UTILITIES BY OTHERS

NOTE:
ALL UTILITY WORK SHOWN ON THIS SHEET WILL BE DONE BY OTHERS. NO PAYMENT WILL BE MADE TO THE CONTRACTOR FOR UTILITY WORK SHOWN ON THIS SHEET.

DocuSigned by:
Ted Gambill X
8/19/2020
Ted Gambill
Technical Services
Frontier Natural Gas Company

# UO-4

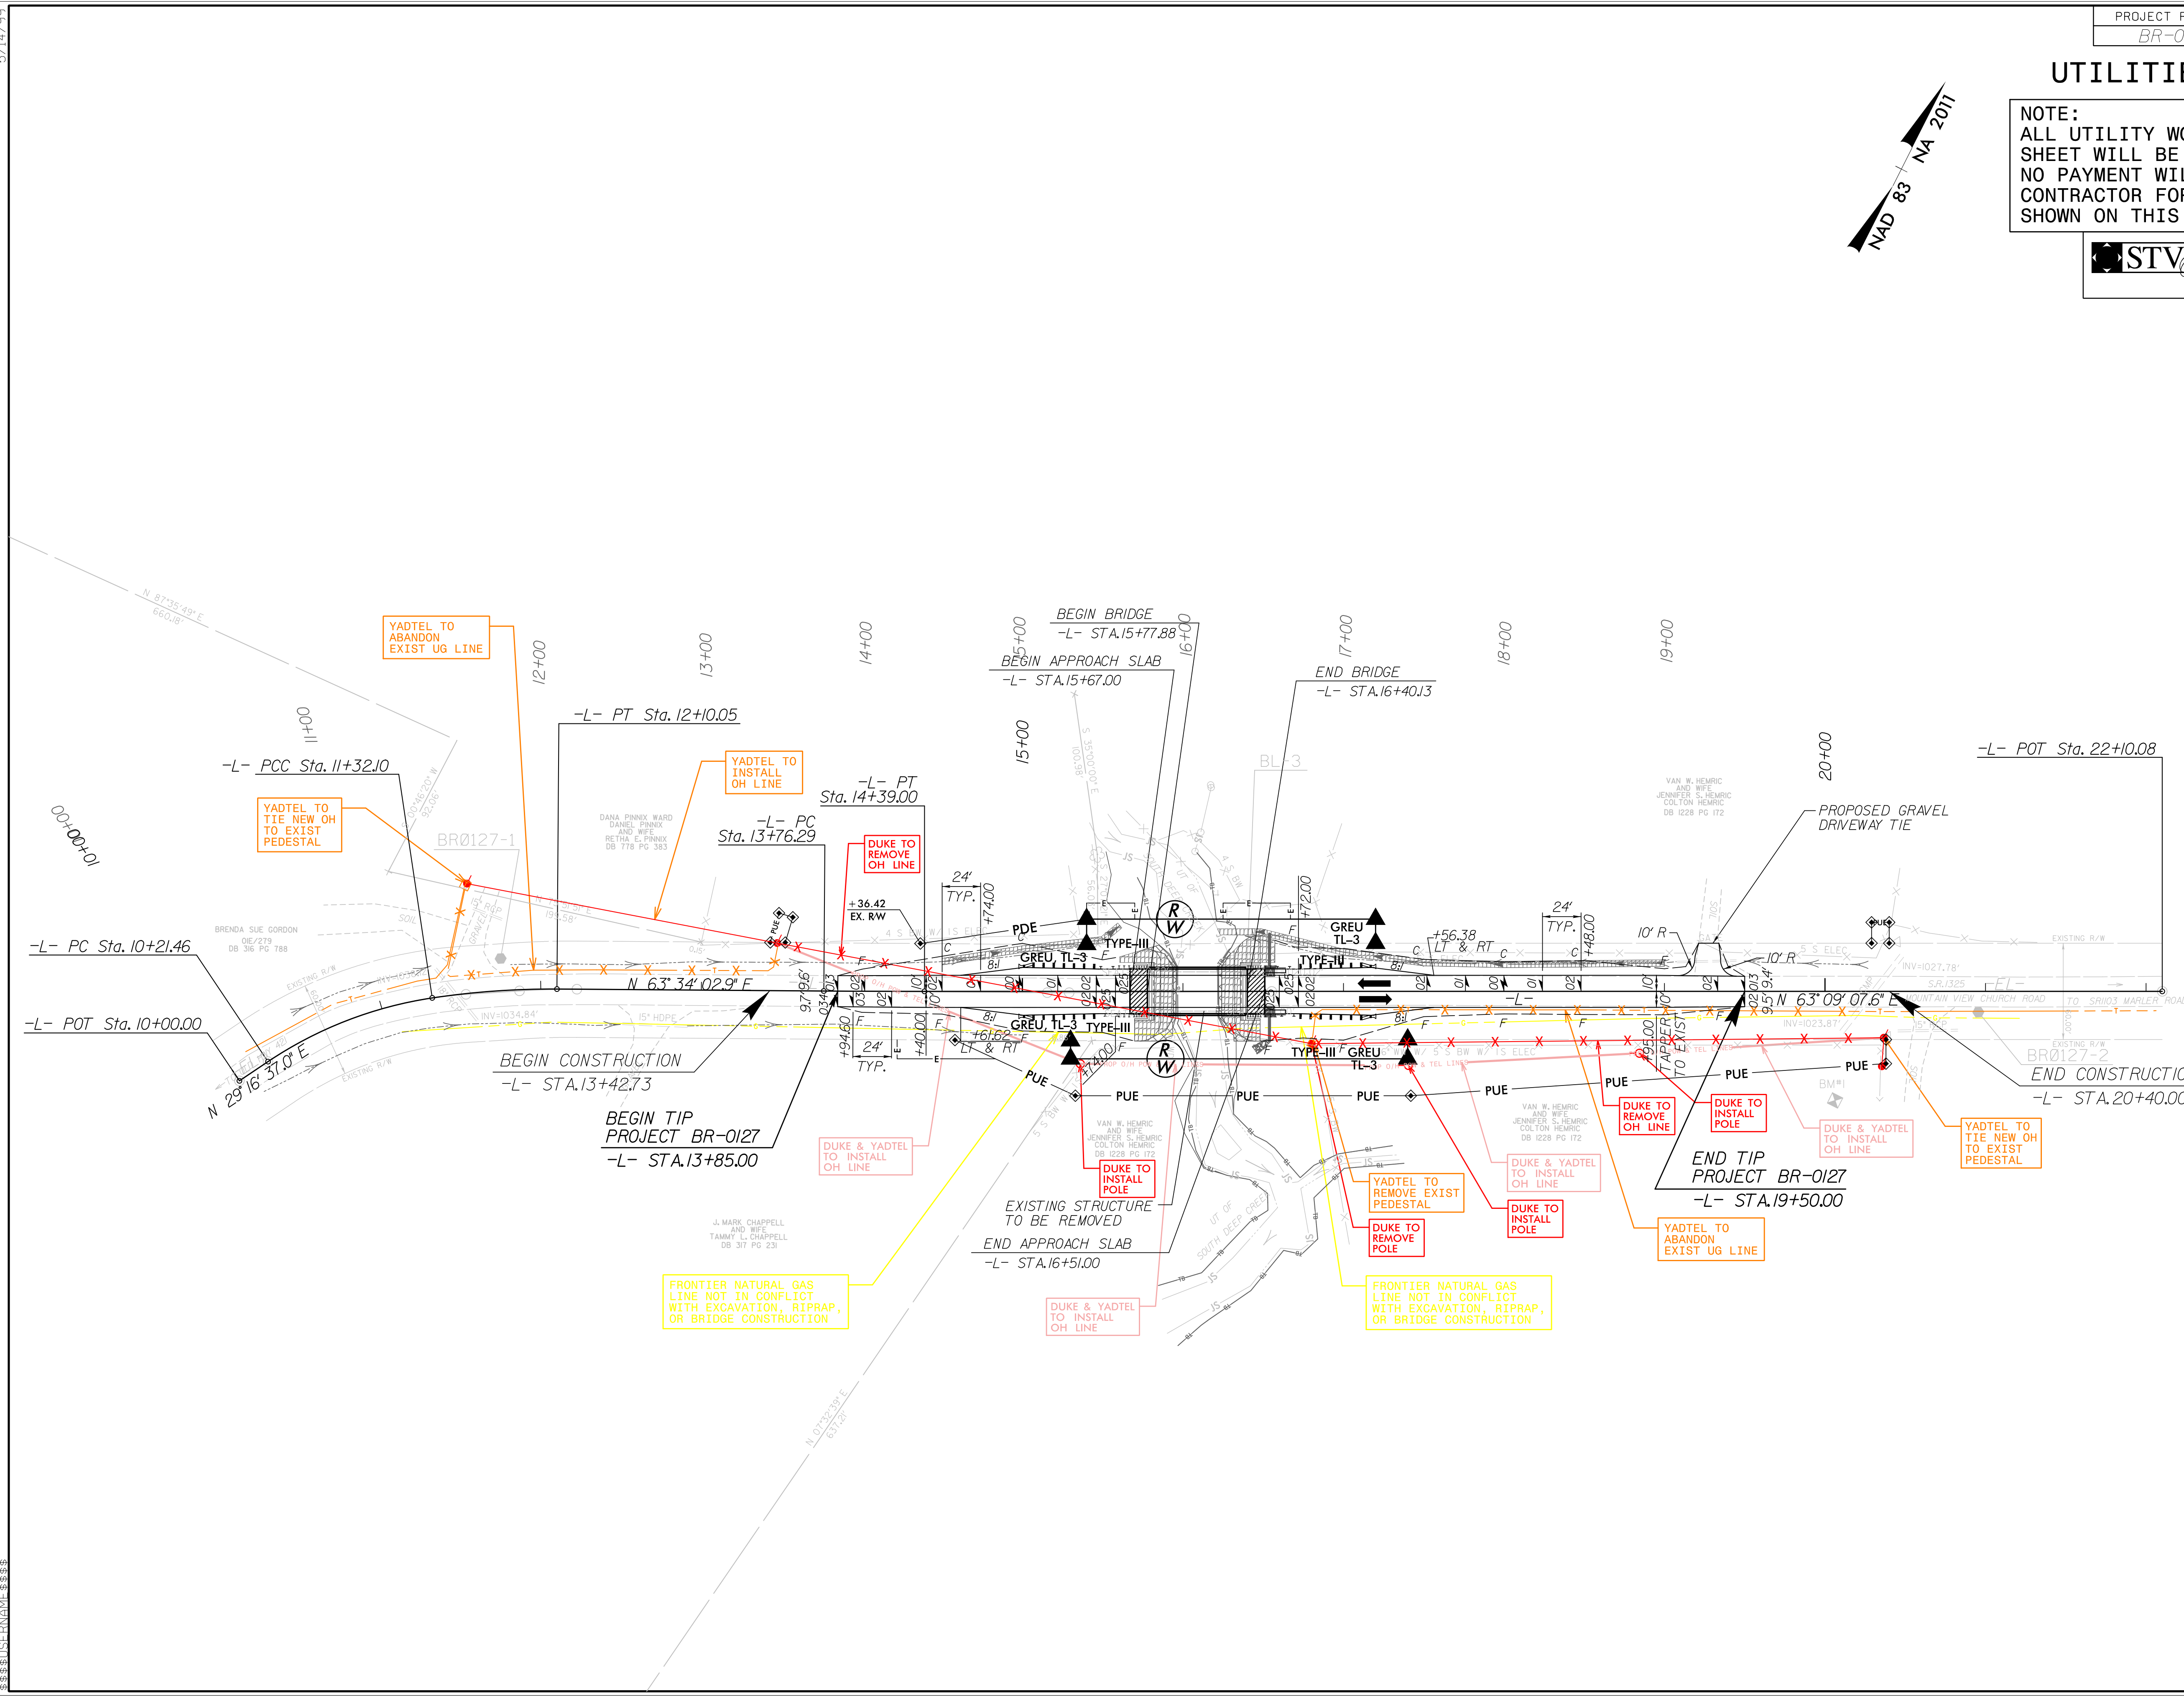
FRONTIER NATURAL GAS LINE NOT IN CONFLICT WITH EXCAVATION, RIPRAP, OR BRIDGE CONSTRUCTION

FRONTIER NATURAL GAS LINE NOT IN CONFLICT WITH EXCAVATION, RIPRAP, OR BRIDGE CONSTRUCTION

I understand that the lines shown on these plans are not level B SUE and are drawn in by record, not by field locates. I concur that with the depths provided by us, Frontier Natural Gas, our lines are not in conflict with this project. I agree with all notes and markups made on this sheet.
